COUNTY COUNCIL'S RESPONSE TO CONSULTATION ON THE FOLLOWING DEVELOPMENT PROPOSAL

Application No: 20/03702/REM-2

Proposal: Reserved Matters to 14/01932/OUT: Spine Road including landscaping and associated infrastructure.

Transport Development Control – Revised response

TITLE  
**SPINE ROAD  
GENERAL ARRANGEMENT SHEET 1 OF 5**

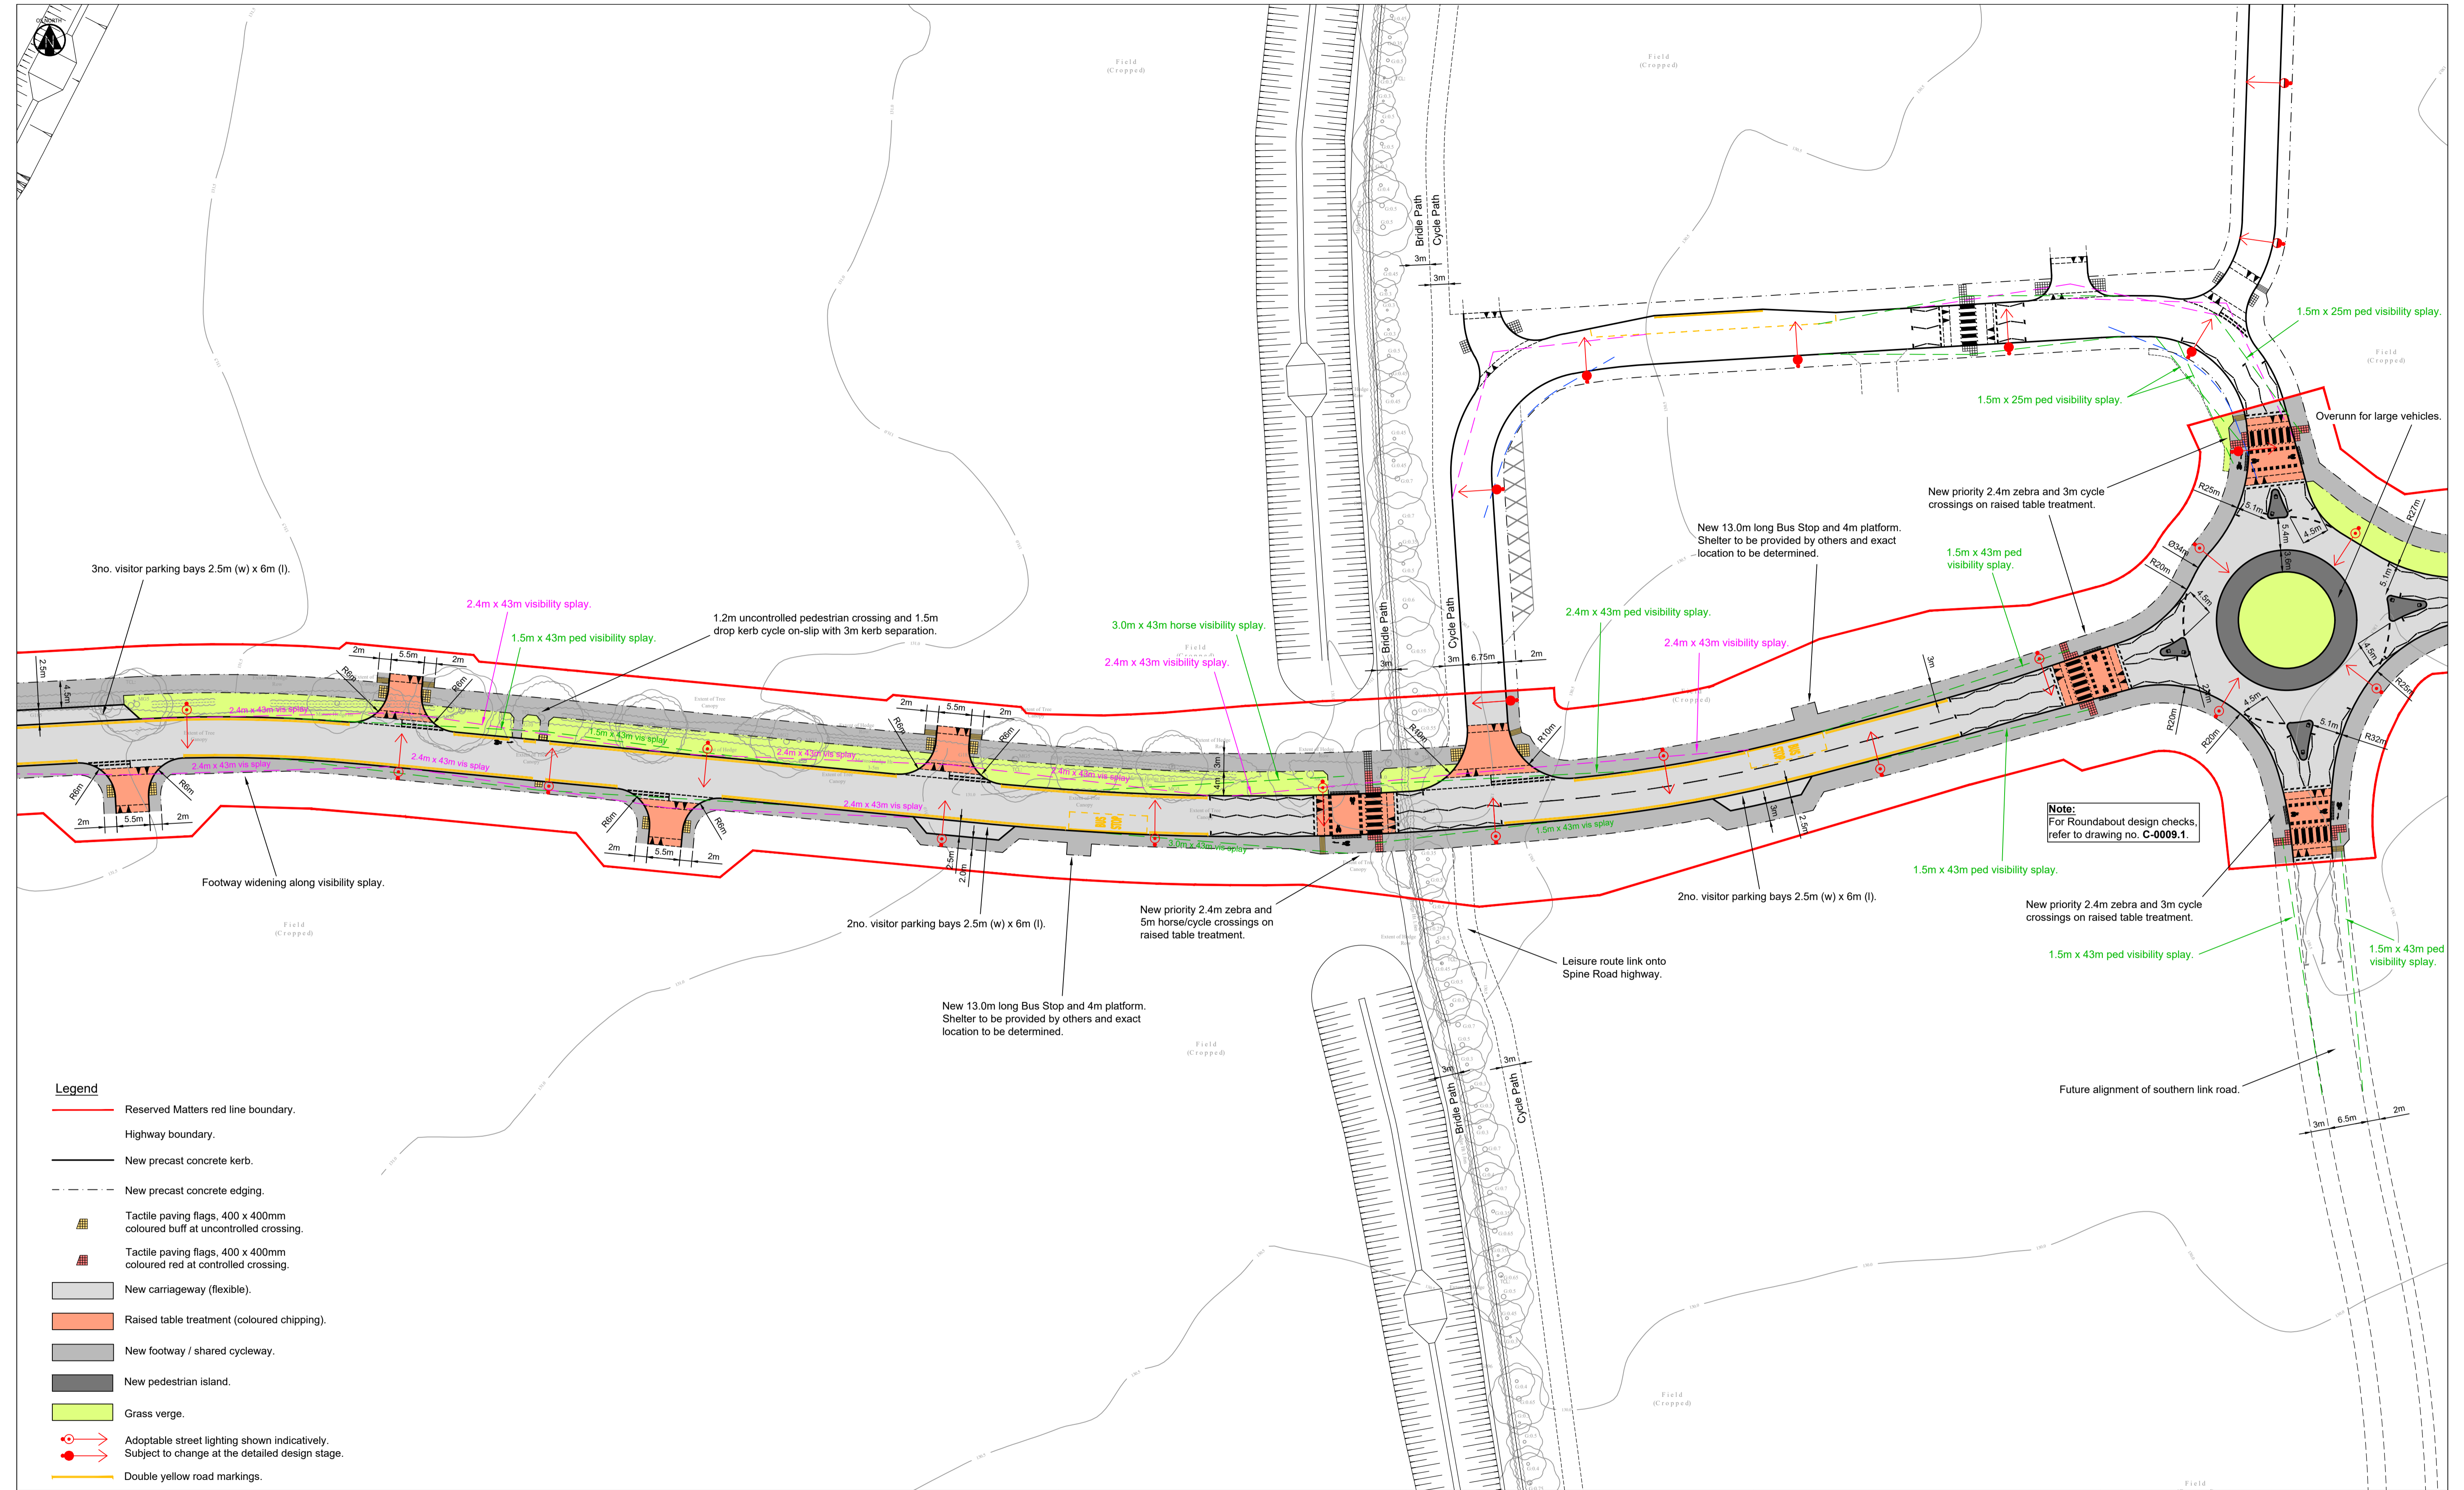
However, we note representations from Stagecoach, who have asked that the bus stops at the local centre are in pull-ins (like the one at the western end of the road) due to possible waiting time leading to dangerous manoeuvres by drivers of other vehicles. We request that this change is made.

Also relating to bus stops, the dimensions of the shelters likely to be provided are 4.5m x 1.5m. The hardstanding area should therefore be increased to 5 x 2m to allow for this. Additionally, the footway connecting the easternmost bus stop to the footway/cycleway should be a minimum of 4m wide.

3.3 – dropped kerbs for cyclists to access the shared use cycleway from the carriageway. Whilst we agree with the principle, the geometry is too severe and the cycle access points need to be tapered.

- Equestrian 'holding areas' should be provided behind the footway/cycleway at the bridleway crossings. Further detail is required.
- The parallel crossing south of the roundabout should be moved slightly closer to the roundabout to be closer to the designer line – there is less chance of waiting vehicles on this arm blocking the circulatory, than on the spine road arms.

- The pedestrian refuges should be widened slightly to 2.4m (though not at the expense of the carriageway width). This is to allow sufficient space for people pushing buggies, wheelchairs and bicycles.

- The swept path analysis for large vehicles passing one another is extremely tight at some points, particularly around the curves at the eastern end of the road. The carriageway should be widened slightly to avoid the chance of vehicles having to slow to a crawl to pass one another safely.

- There will need to be additional informal tactile crossing points at the eastern end of the road.

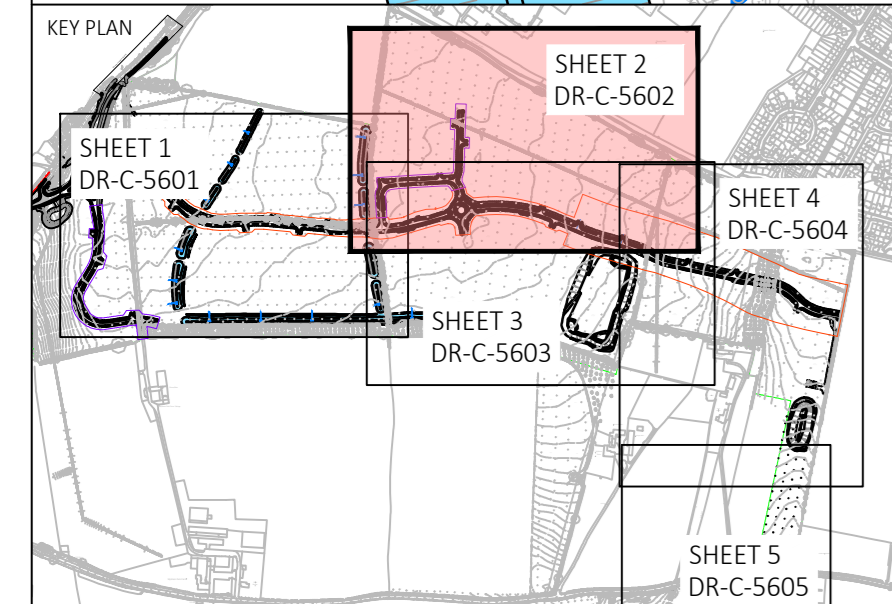
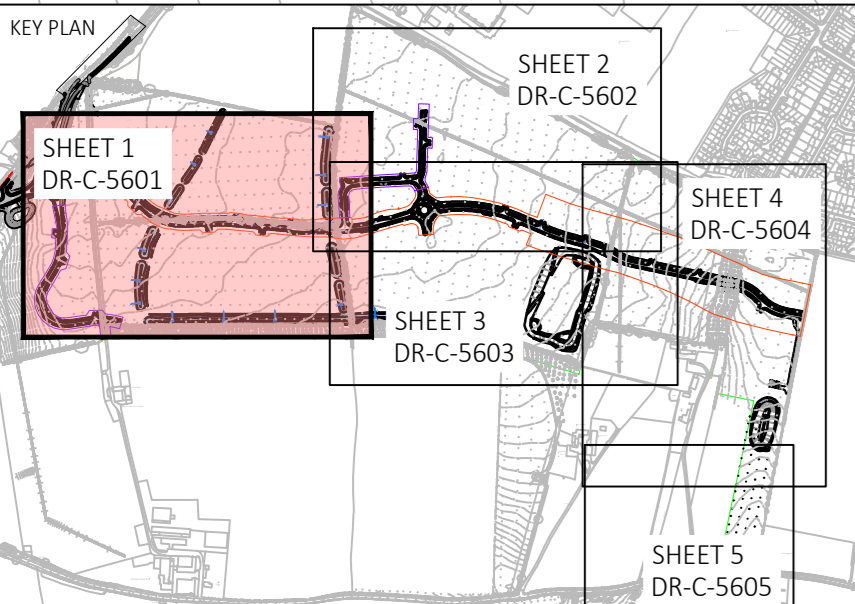
The LLFA believe the drainage strategy proposed is not in full compliance with Local Standards and Guidance for Surface Water Drainage on Major Development in Oxfordshire.

With the scale of site, LLFA believe more SuDS can be implemented at source adjacent to the carriageway. The width of carriageway proposed has more than enough capacity to accommodate SuDS such as filter drain and swales.
